EPC STORMWATER REVIEW COMMENTS  
IN ORANGE BOXES WITH BLACK TEXT

PAINT BRUSH HILLS PUMP HOUSE NO. 6  
DESIGNED BY  
DRAWN BY  
JOB NUMBER  
DATE  
SCALE  
DRAWING DESCRIPTION  
SHEET NO.

DESIGNED BY: JGS  
DRAWN BY: JS/RG  
JOB NUMBER: 1070.0014  
DATE: 5/4/23  
SCALE: 1" = 20'  
DRAWING DESCRIPTION: GRADING/EC PLAN  
SHEET NO: 6 of 17

DRAWN BY	JGS	DESIGNED BY	JS/RG
JOB NUMBER	1070.0014		
DATE	5/4/23		
SCALE	1" = 20'		
DRAWING DESCRIPTION	GRADING/EC PLAN		
SHEET NO.	6	OF	17

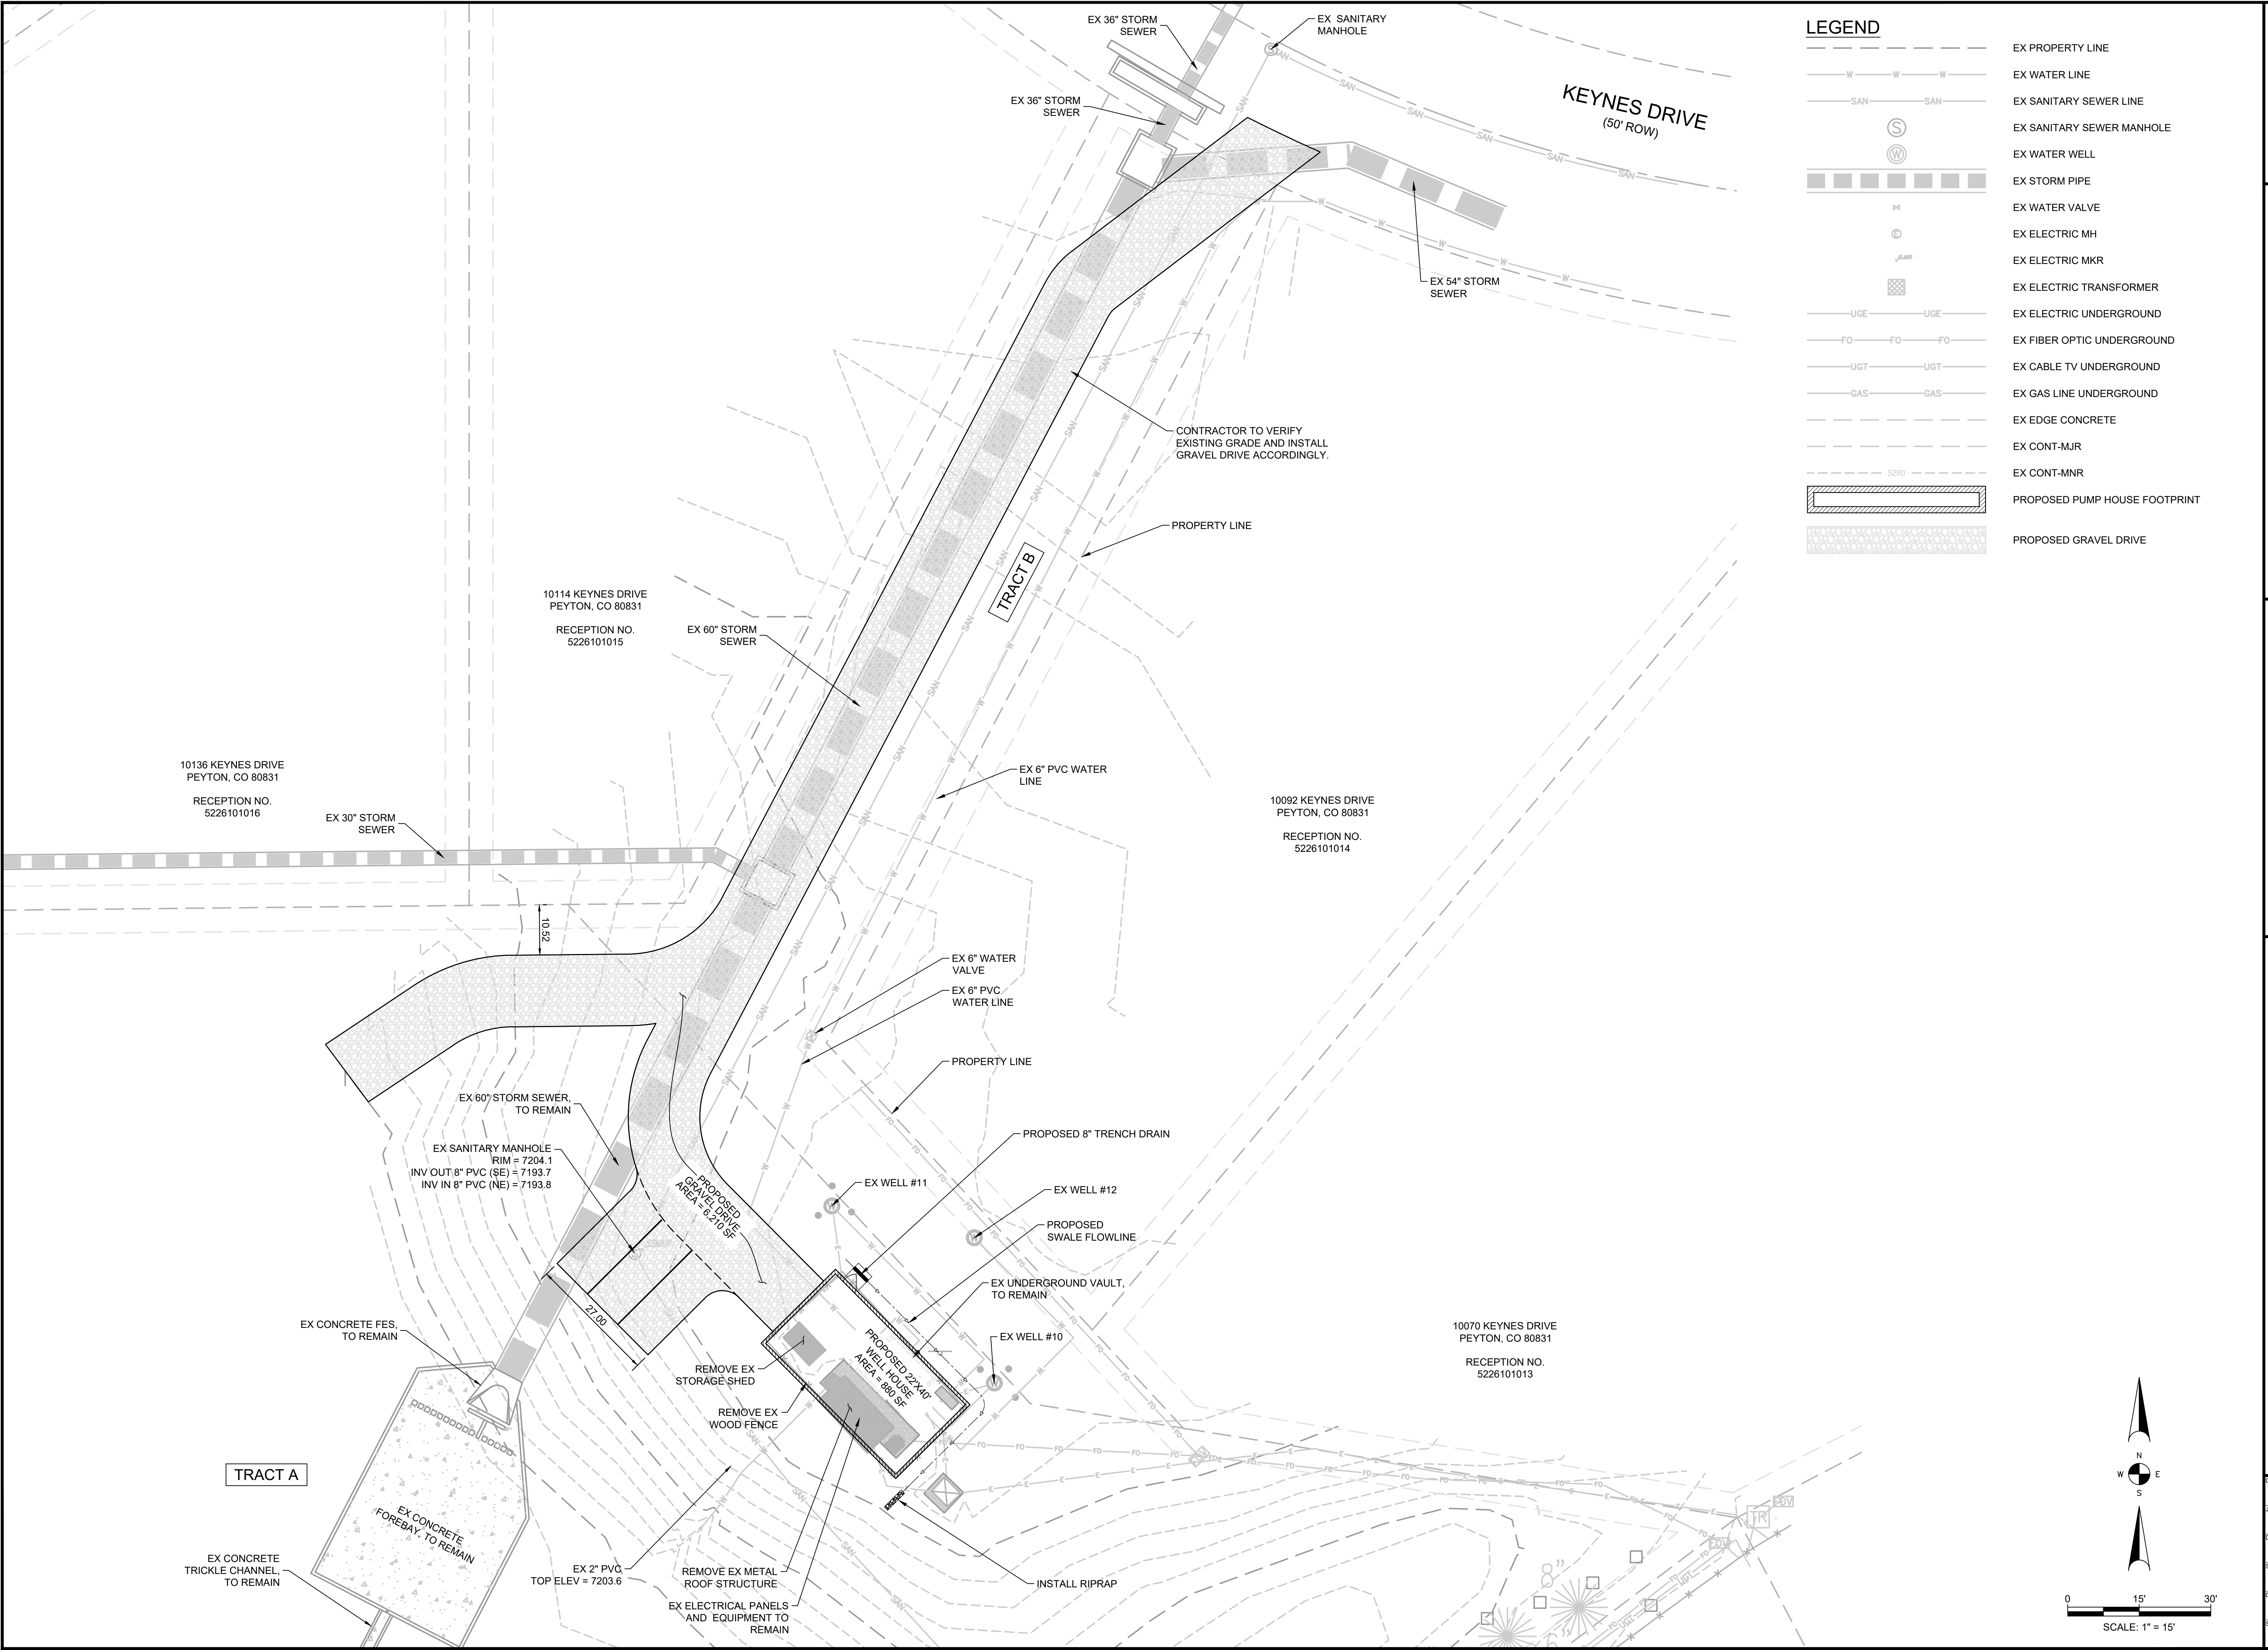
SWMP Checklist Item 17c - show all areas of disturbance (limits of construction can be labeled "limits of construction/disturbance")  
SWMP Checklist Item 17d - Show all areas of cut/fill - can just add cut/fill line limits to legend and show on plans  
SWMP Checklist Item 17i - Add a note that states there are no dedicated asphalt/concrete batch plants or show plants on the plans.

Extend construction boundary to incorporate grading and BMP installation that is currently outside of the boundary. Typical callout.

provide detailed cross section of swale

hatching doesnt match the figure

VTC pattern on plans does not match the legend.

If CD and SCL are not proposed - remove from legend or show on plans.

Provide detail/cross-section for proposed swale. And label as initial, interim, or final.

Is this riprap? If so discuss and provide calculations for in the drainage letter and provide detail. Provide calcs for the swale design.

GEC Checklist Items aa & bb - show and label off-site WQ control measures. (label existing pond with pond name)

There is no ditch at this outfall. Channelized flow will cause erosion if there is not a suitable outfall to receive the concentrated flow.
